Application no: H18-0571-15

Description: Proposed new dwelling

Location: 62 NEW ROAD
SUTTON BRIDGE
SPALDING
PE12 9RQ

PLANNING AMENDMENT

773-01 d

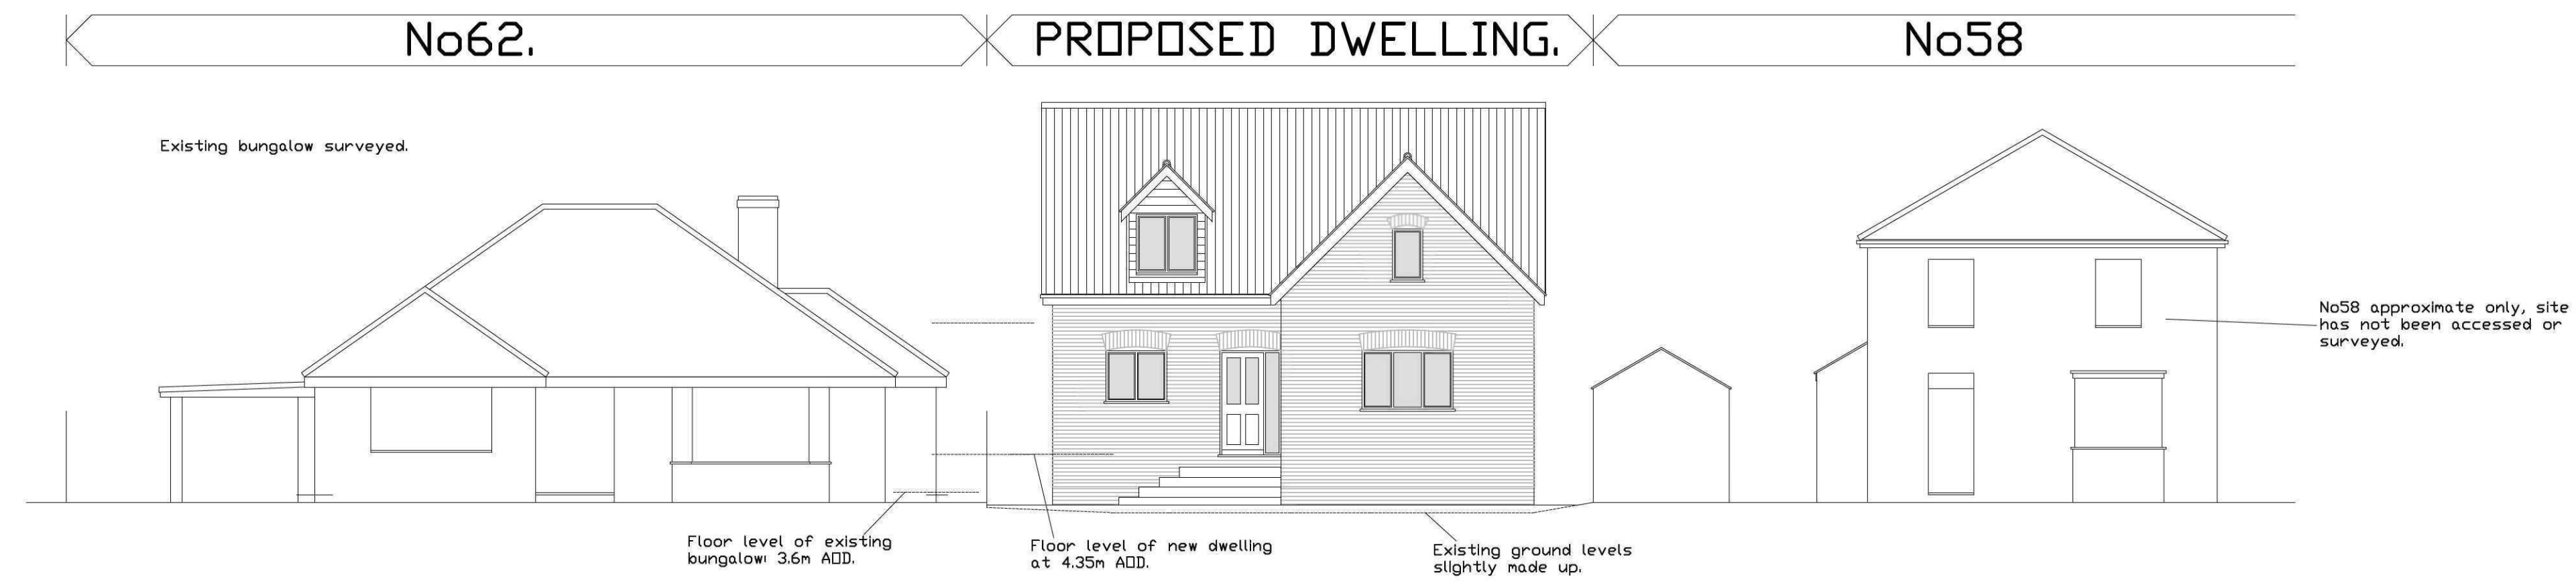
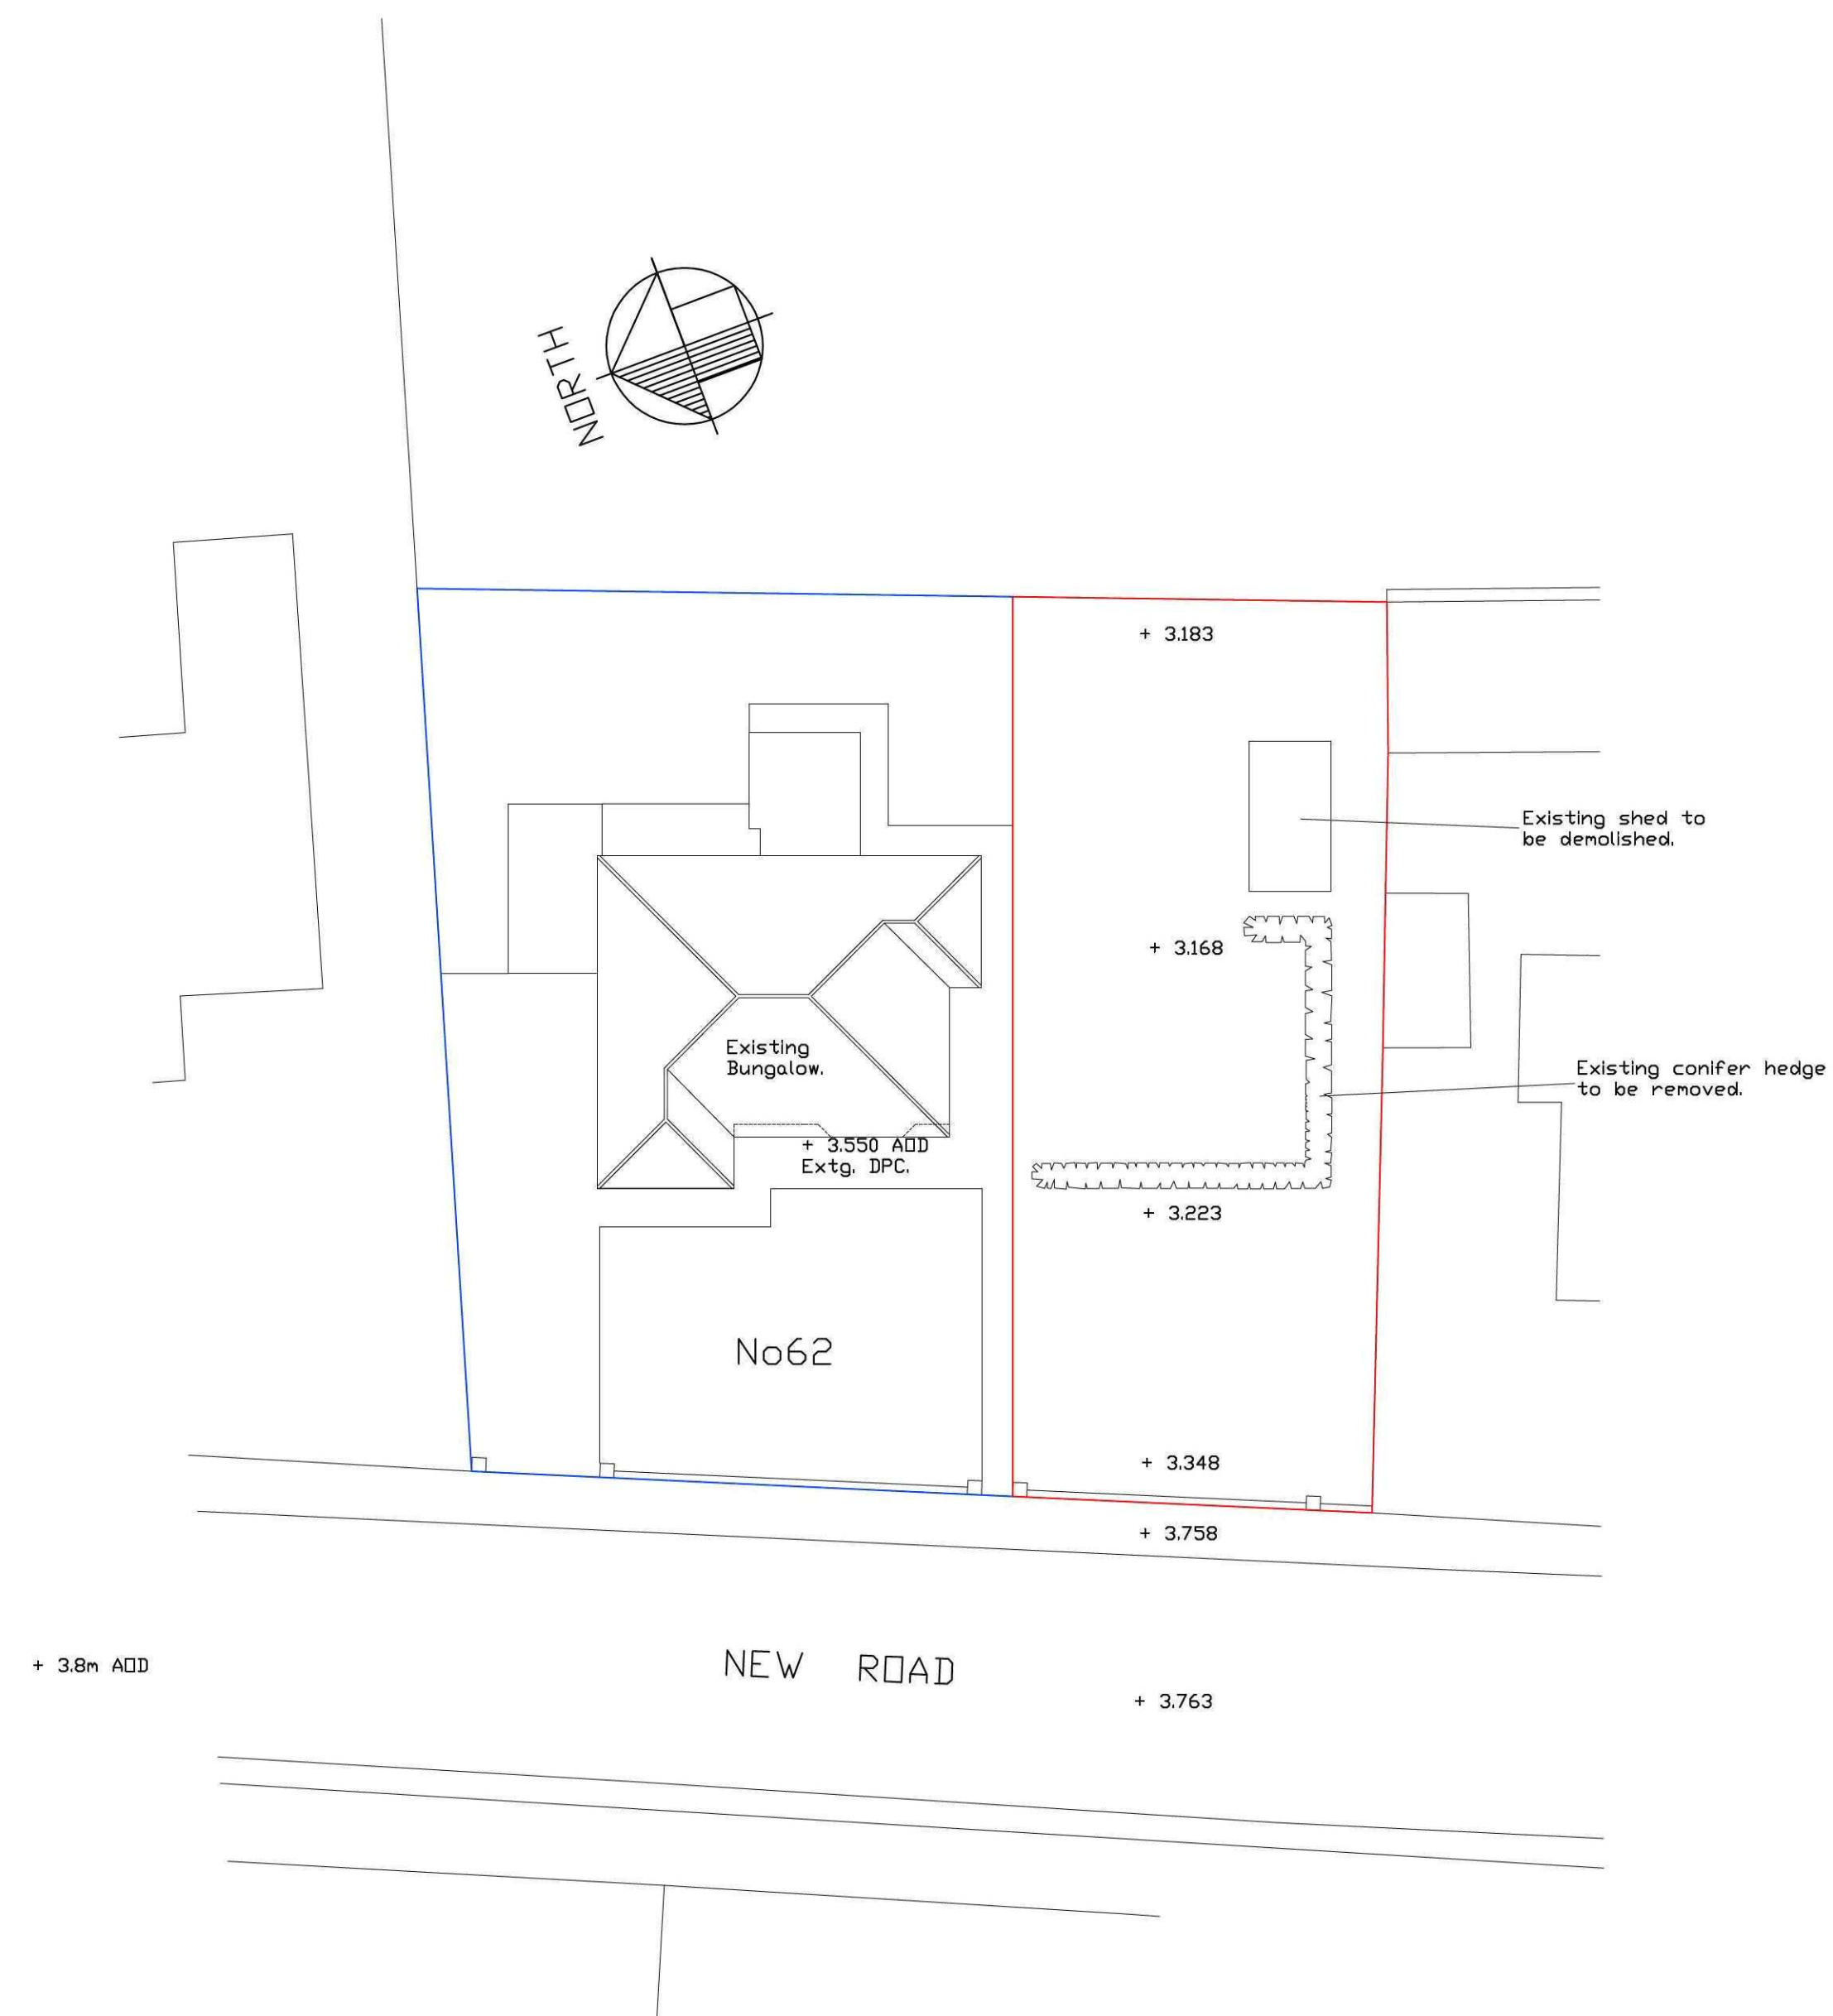
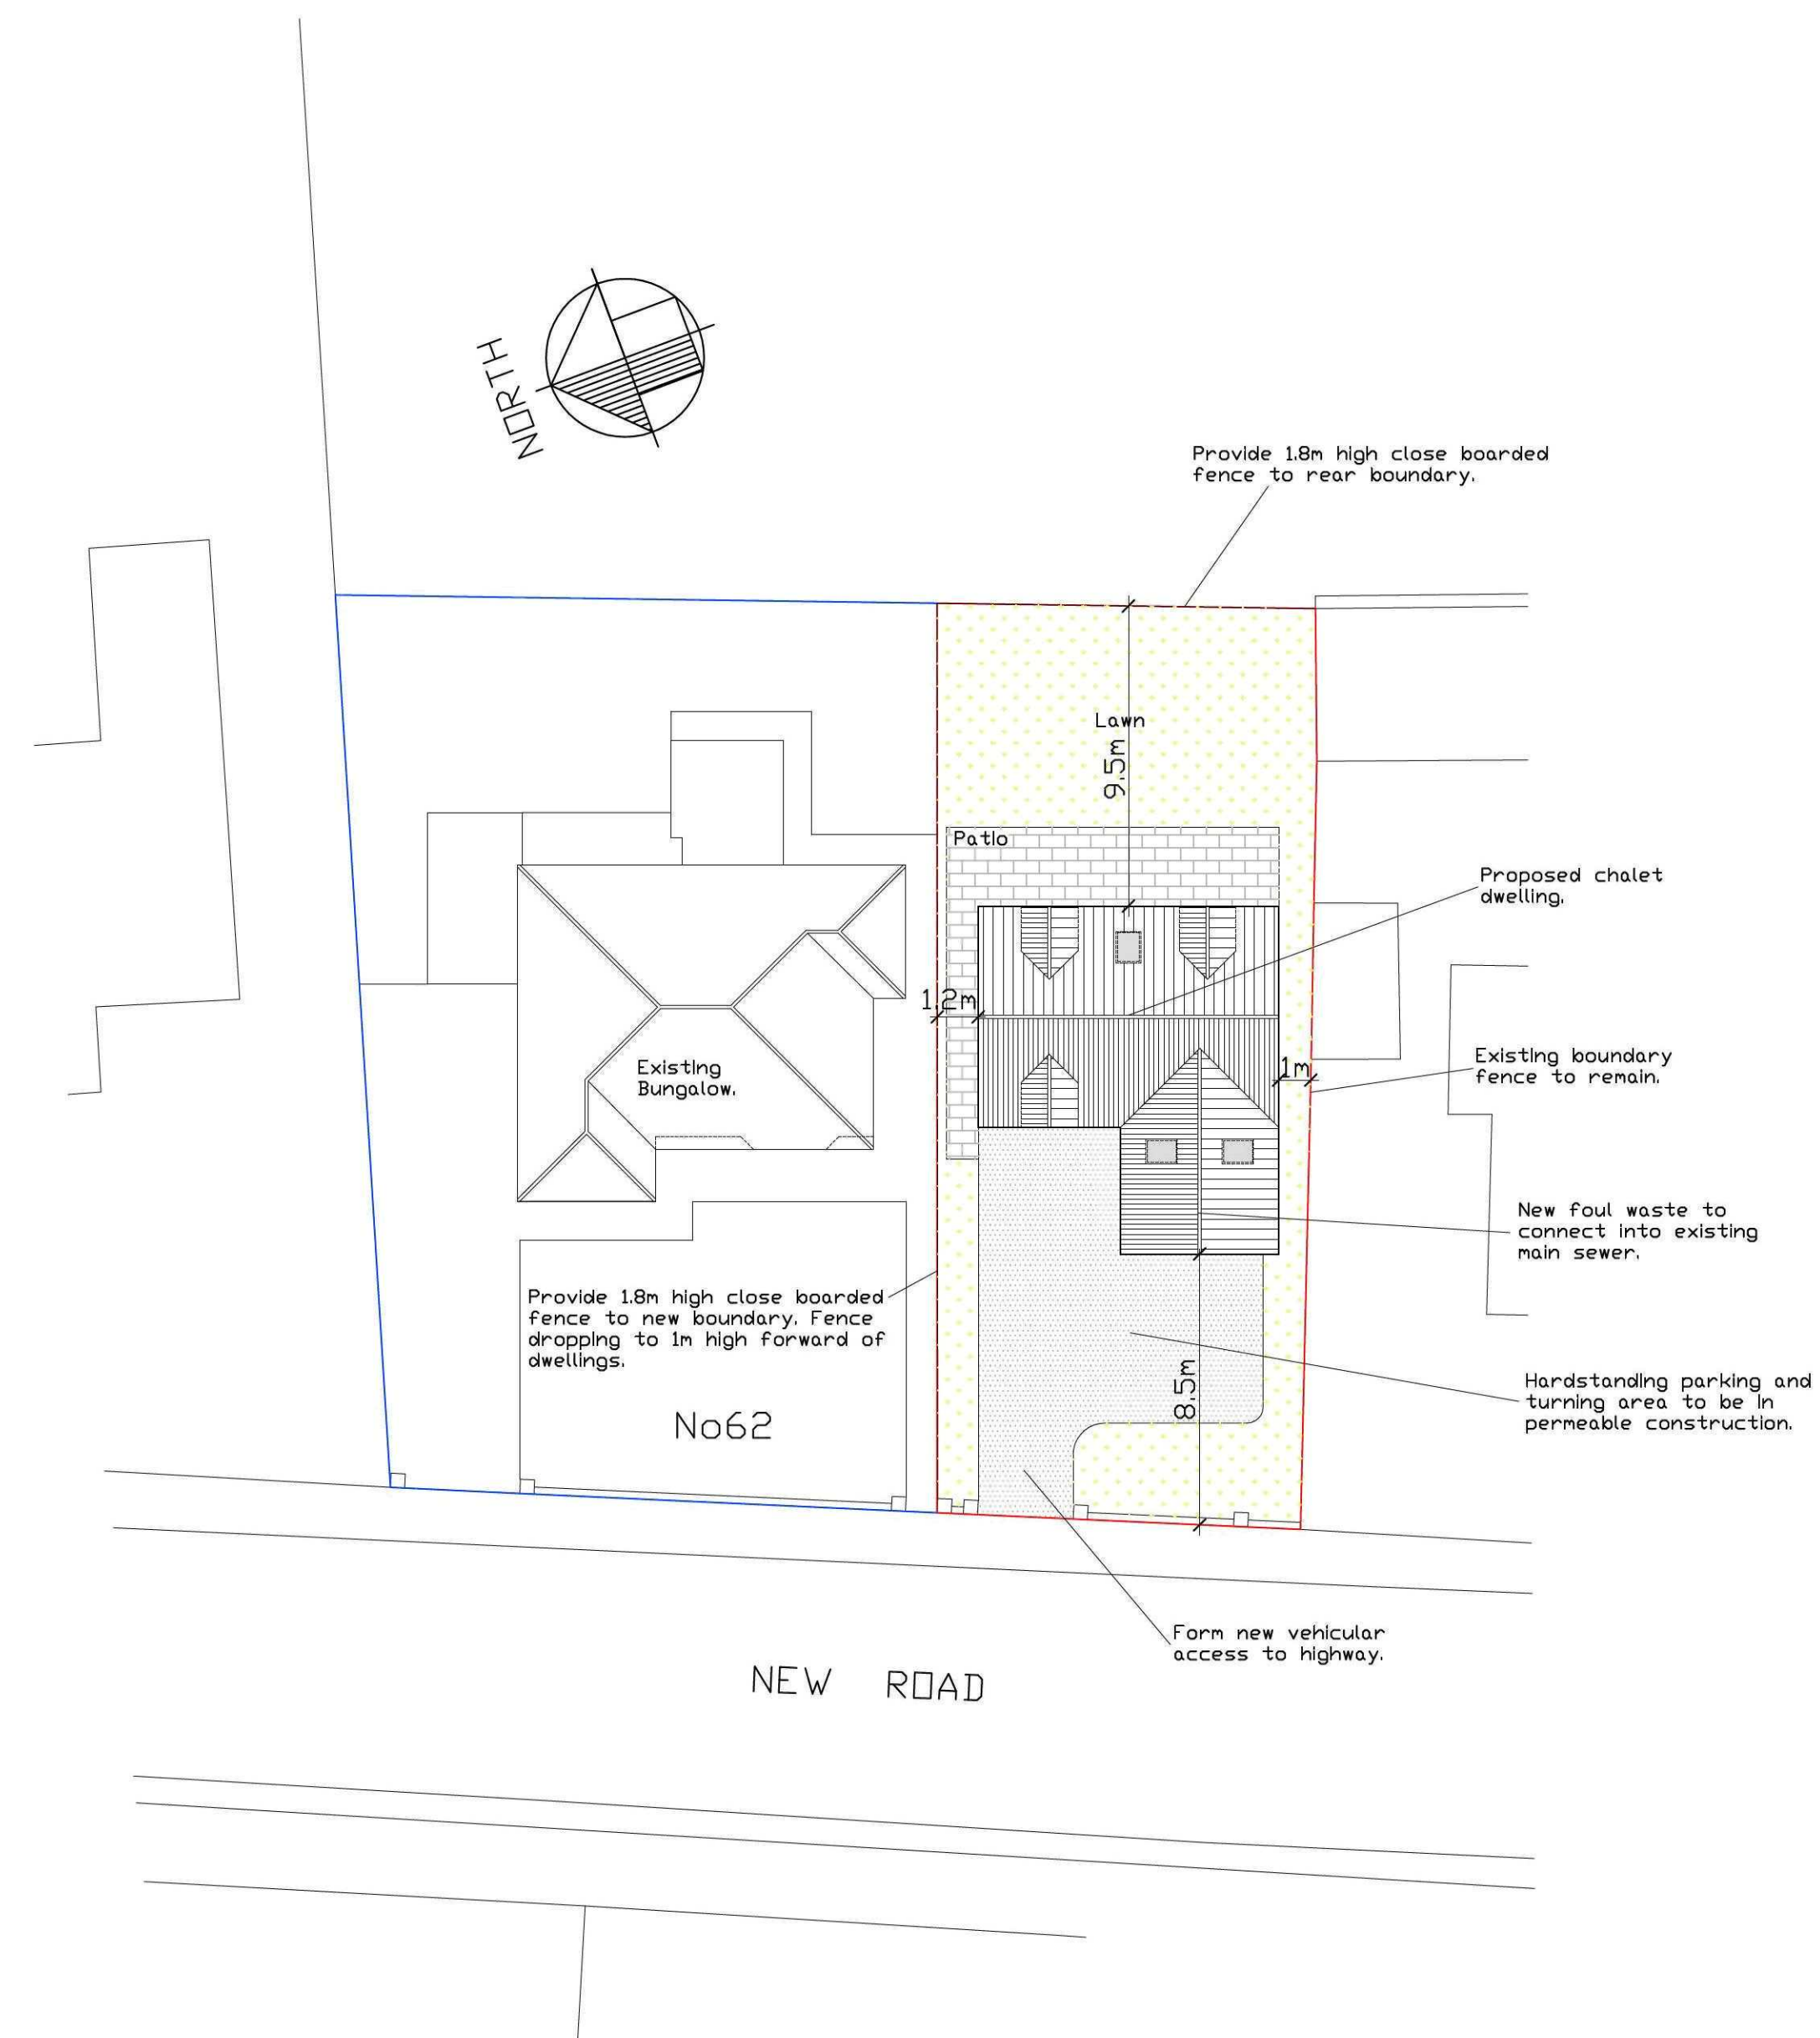
Amendment: Floor levels/buildings raised to suit Environment Agency requirements (dwgs 773-01d, 773-02b & Flood Risk Ass)

I refer to your recent e-mail and attach a completed amendment form together with the revised FRA for this project and amended drawings 773-01d & 02b that now show the ground floor level raised in accordance with EA's requirements.
